**Consultation Response from Alan Smith,
KC Waste Strategy (Refuse & Recycling)**

2024/90255 Land Off, Burn Road, Birchencliffe, Huddersfield, HD3 3BT

Date Responded: 07/08/2025

Responding Ref: WPS 25 027

DRAWING TITLE
VEHICLE TRACKING DRAWING

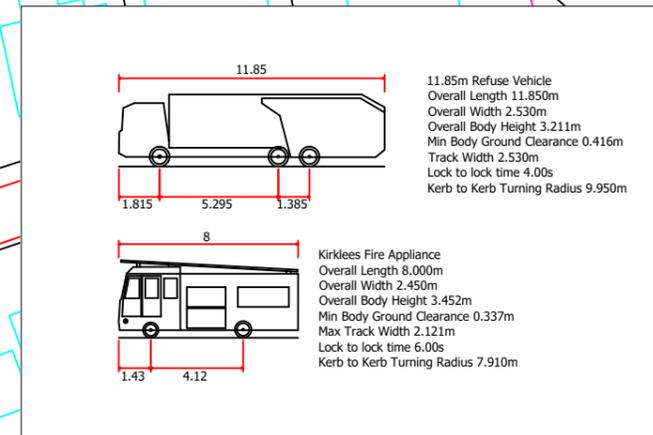
- It is welcomed that the turning head is active, this should reduce the likelihood of cars being parked impeding the refuse collection service. Reversing is a recognised safety risk for crews and pedestrians. **The Waste Industry Safety and Health (WISH) Forum guidance states "Reversing causes a disproportionately large number of moving vehicle accidents in the waste/recycling industry. Injuries to collection workers or members of the public by moving collection vehicles are invariably severe or fatal. BS 5906: 2005 recommends a maximum reversing distance of 12 m."**

- Where turning is necessary, the turning facilities must be demonstrably sufficient for an 11.22m refuse collection vehicle. **Active measures should be taken to prevent parking in the turning head as otherwise an RCV would have a very long reverse manoeuvre which is a recognised safety risk and is not acceptable.**

- Swept path analysis must show the manoeuvrability of this vehicle throughout the site, demonstrating the safe passing of other vehicles likely to be using the road – either parked or moving.
